Your reference: SSD-71547218

Development Application

**State Significant Development – EIS & DA Exhibition – Waste or resource management facility
8 Styles Street Kurri Kurri NSW 2327, 1//DP1309128**

The RFS has reviewed the bush fire hazard assessment, undertaken in the bush fire report prepared by Cool Burn Pty Ltd (Version 1.1 and dated 12 February 2025) to demonstrate compliance of the proposed works with relevant provisions of Planning for Bush Fire Protection (PBP) 2019.

Weighbridge Shed - East Elevation  
Scale: 1 : 100

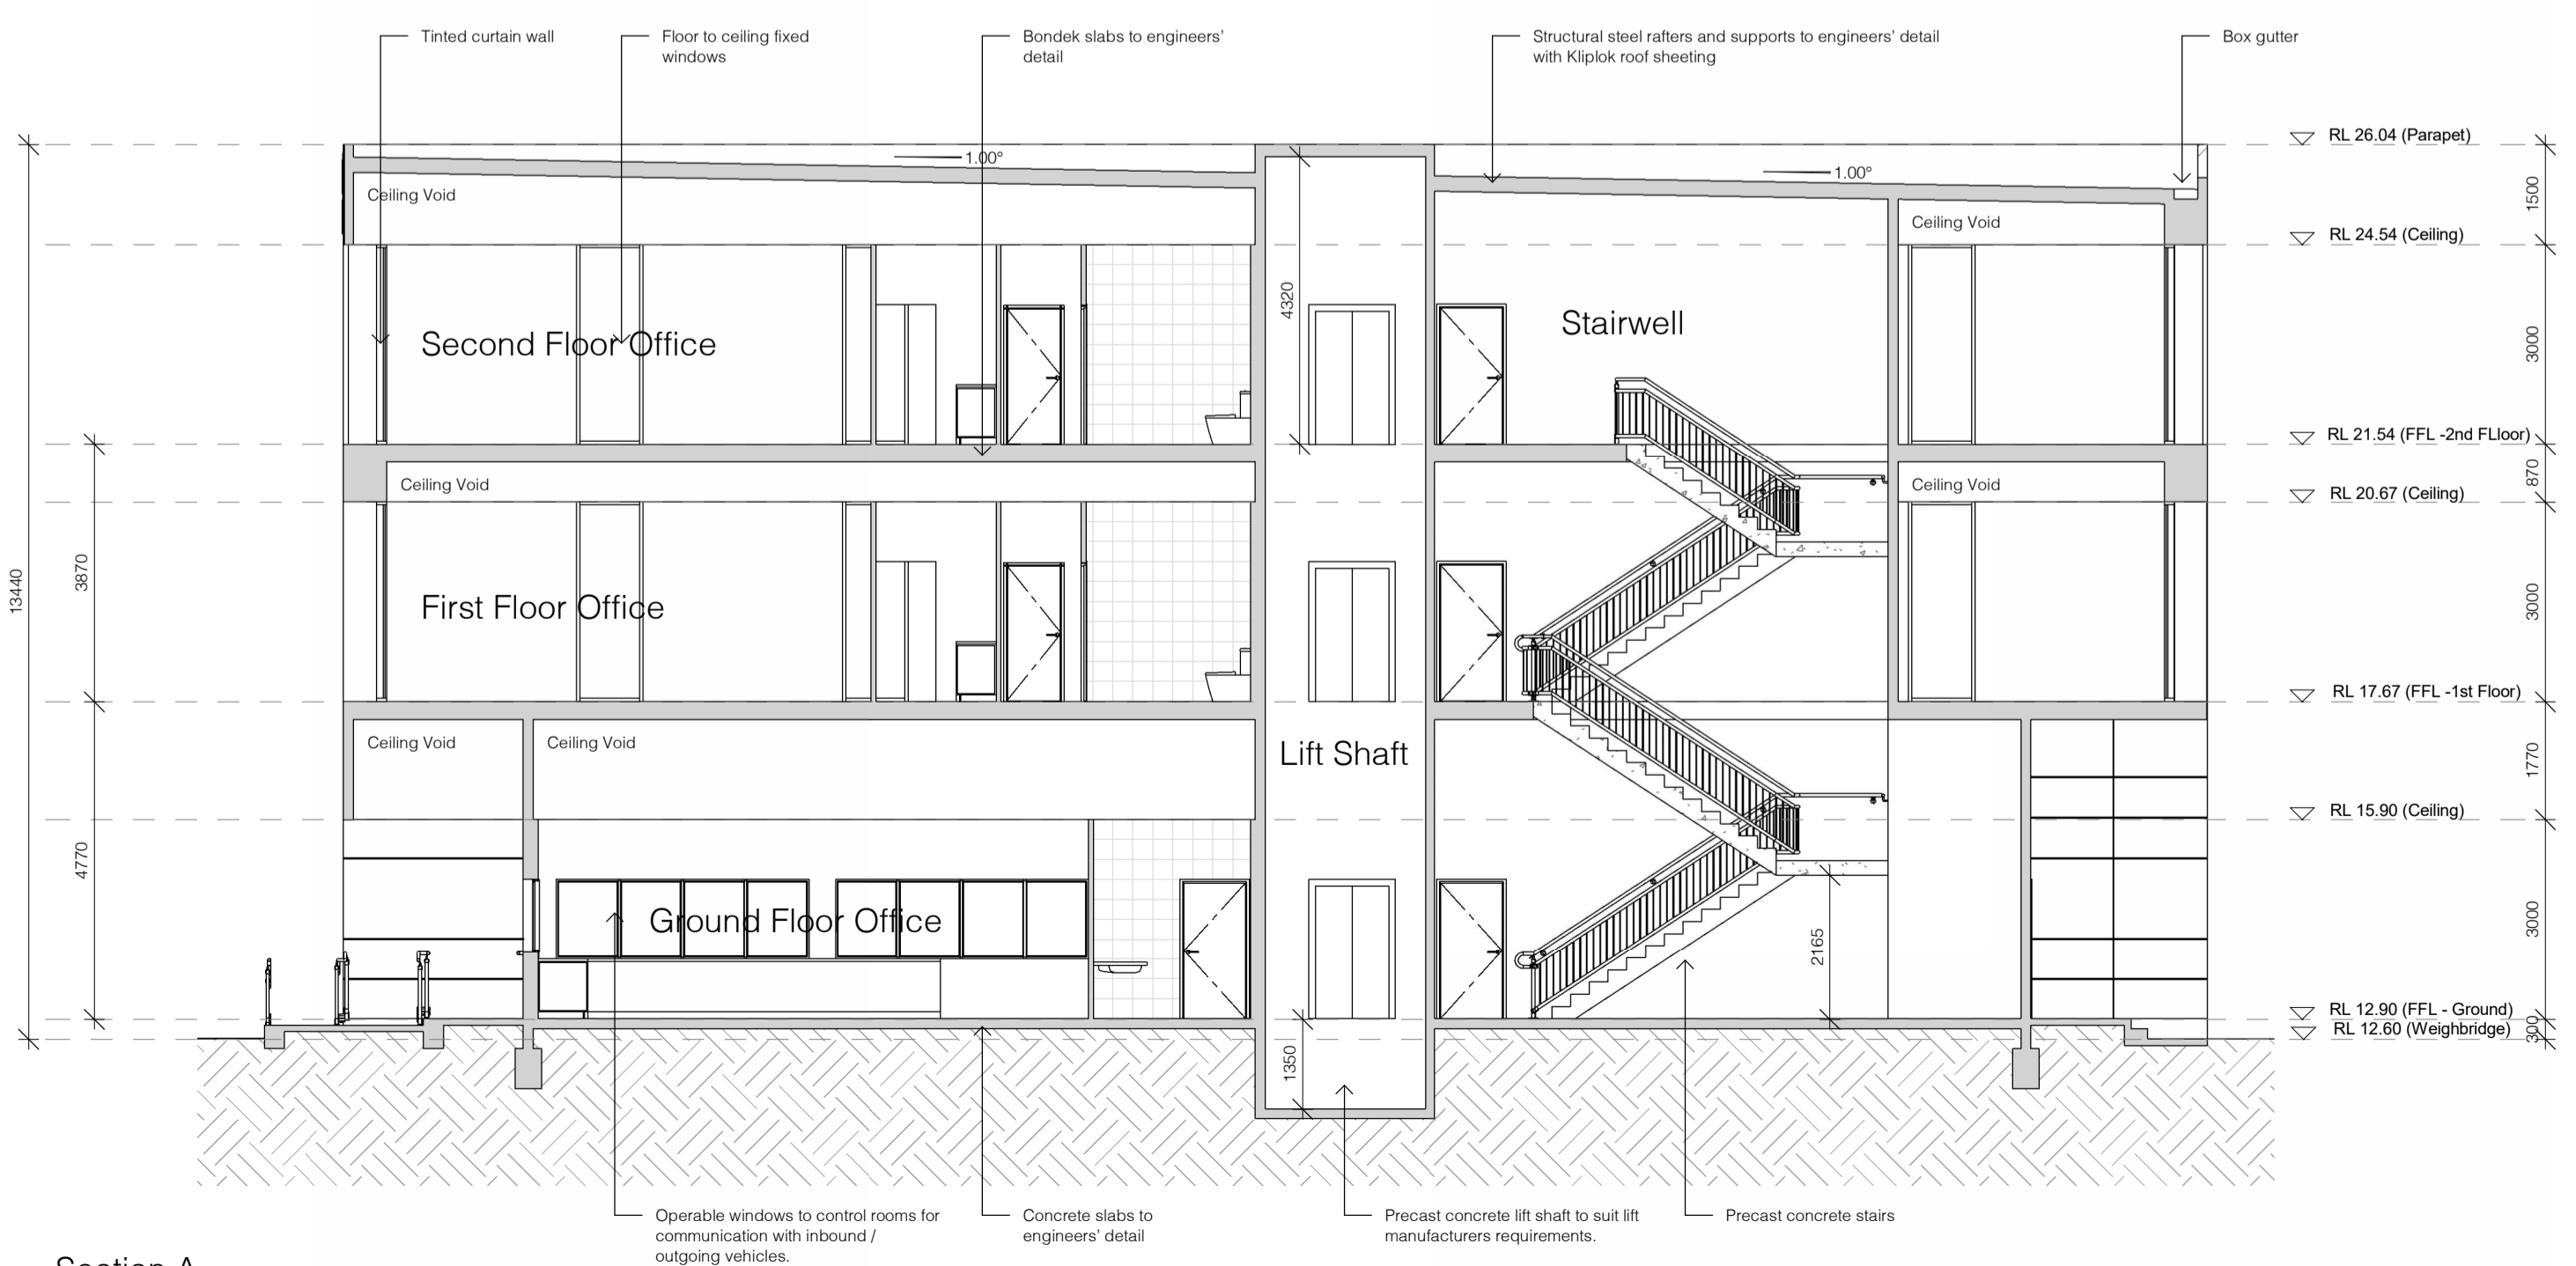
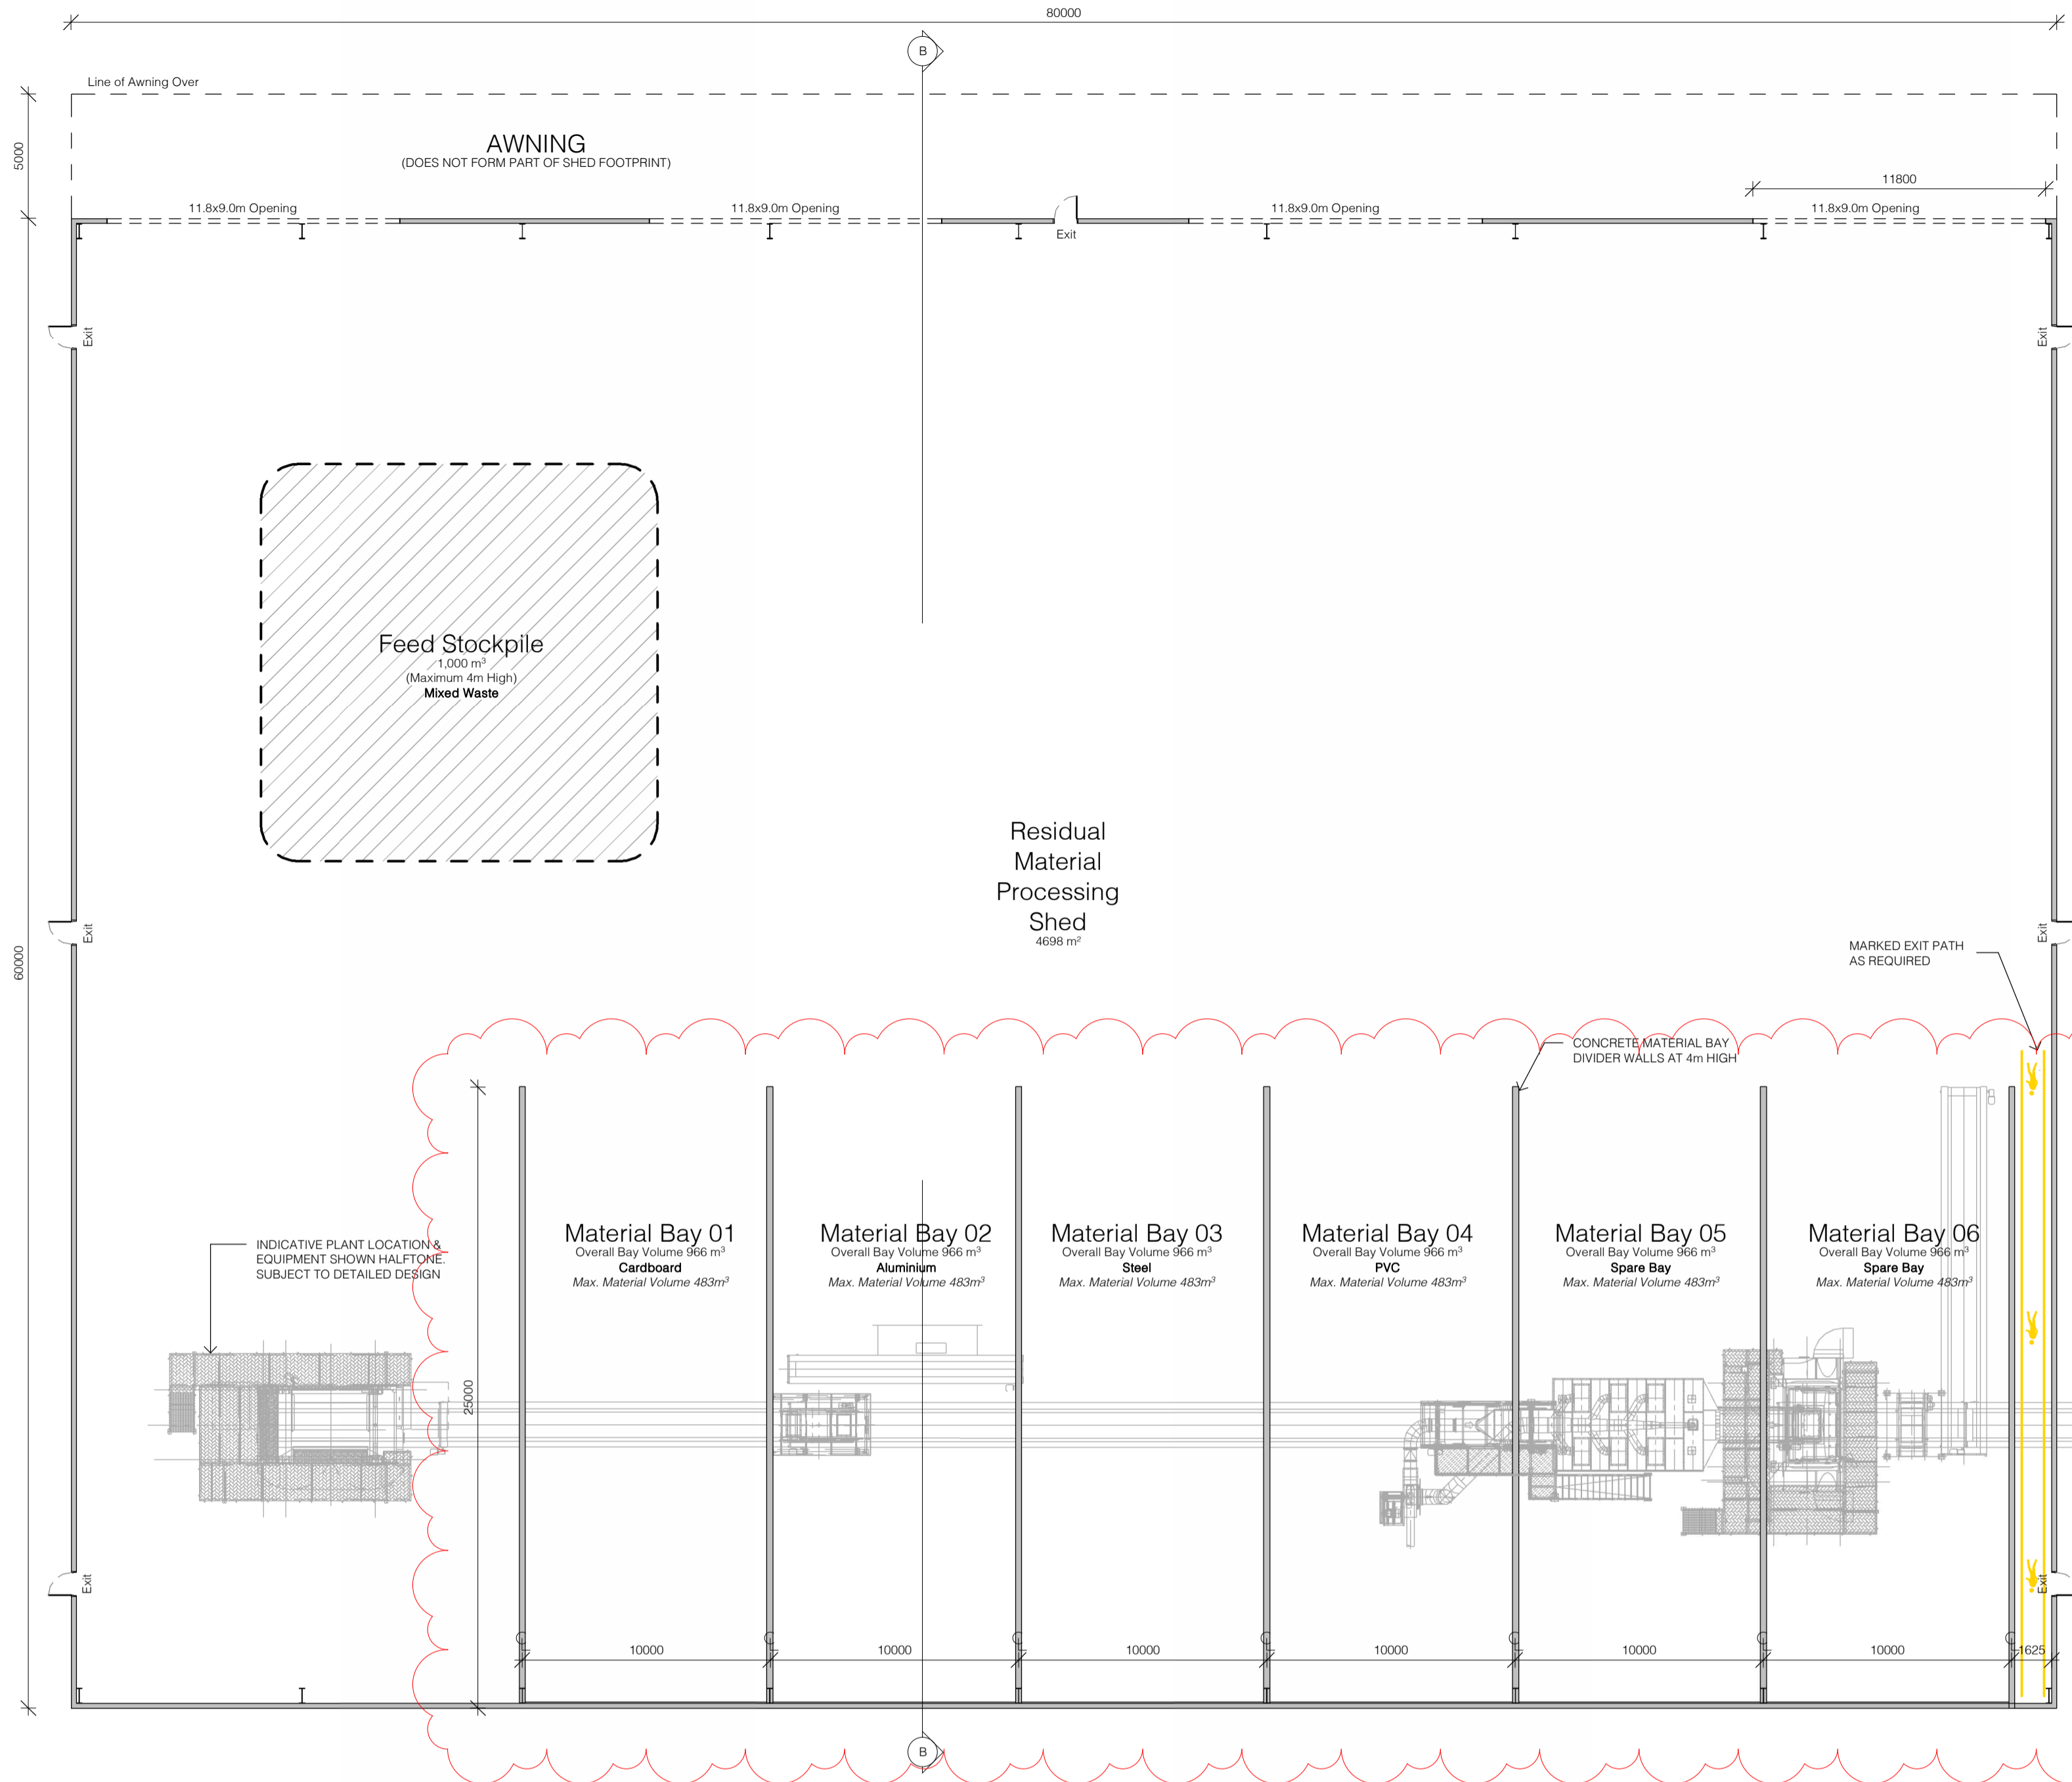
5. The proposed offices located above the weighbridge, must be upgraded to improve ember protection by enclosing all openings (excluding roof tile spaces) or covering openings with a non-corrosive metal screen mesh with a maximum aperture of 2mm. Where applicable, this includes any sub floor areas, openable windows, vents, weepholes and eaves. External doors are to be fitted with draft excluders.
